Appeal Decision

Appeal Ref: APP/R5510/W/25/3368197

65 High Street, Ruislip, Hillingdon HA4 8JE

- The appeal is made under section 78 of the Town and Country Planning Act 1990 (as amended) against a refusal to grant planning permission.
- The appeal is made by Mr J Sagoo (Sagoo Group Ltd) against the decision of the Council of the London Borough of Hillingdon.
- The application Ref is 6786/APP/2024/2989.
- The development proposed is first floor new build self-contained two-bedroom dwelling on top of rear of existing building, with associated bin and bicycle storage at ground level.

DRG TITLE
Proposed
First floor plan

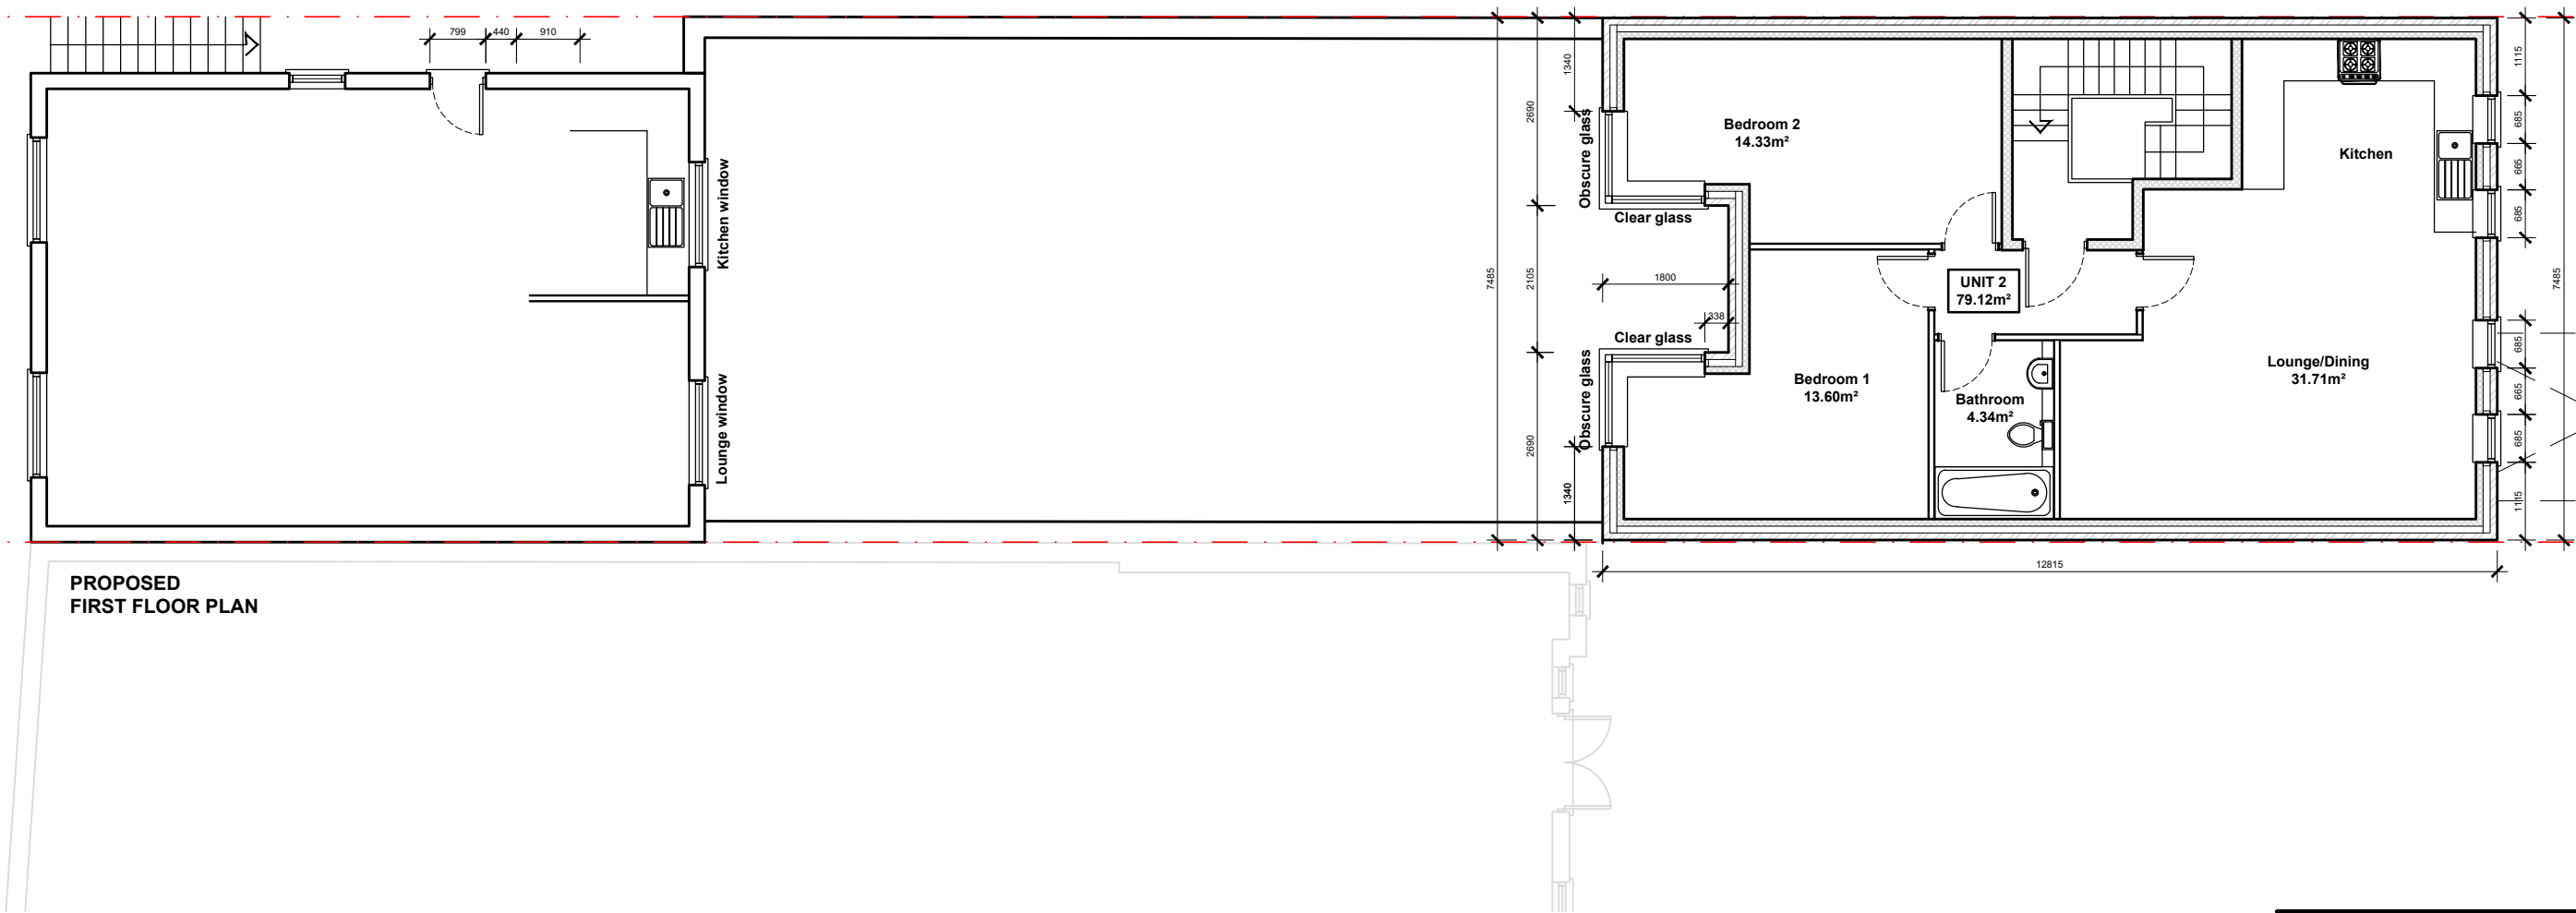
8. A fence is proposed to separate the two amenity areas and provide privacy between the existing flat at No. 65 and the proposed flat. However, a high fence in such close proximity to the rear of the flats would severely restrict the outlook of the occupiers from the habitable rooms at the rear of the properties. Whilst the view of the flat roof currently experienced from No.65 is not the most attractive, it does allow views beyond this towards the houses and trees on Midcroft, providing a sense of space. Construction of the proposed flat and fence would significantly harm the current open outlook. The high fence would also feel overbearing when outside the proposed and existing flat, creating amenity areas that feel enclosed and not pleasant spaces to spend time in.

9. It is not clear from the plans how occupiers of the proposed flat would access the amenity areas as only windows are shown at the rear of the property, with no side access. Whilst not shown on the existing or proposed plans, I noted on my site visit that the flat roof at the rear contained roof lights, air conditioning units and other infrastructure serving the commercial premises below. This would severely hinder the use of the proposed amenity space and restrict room for domestic outdoor paraphernalia.
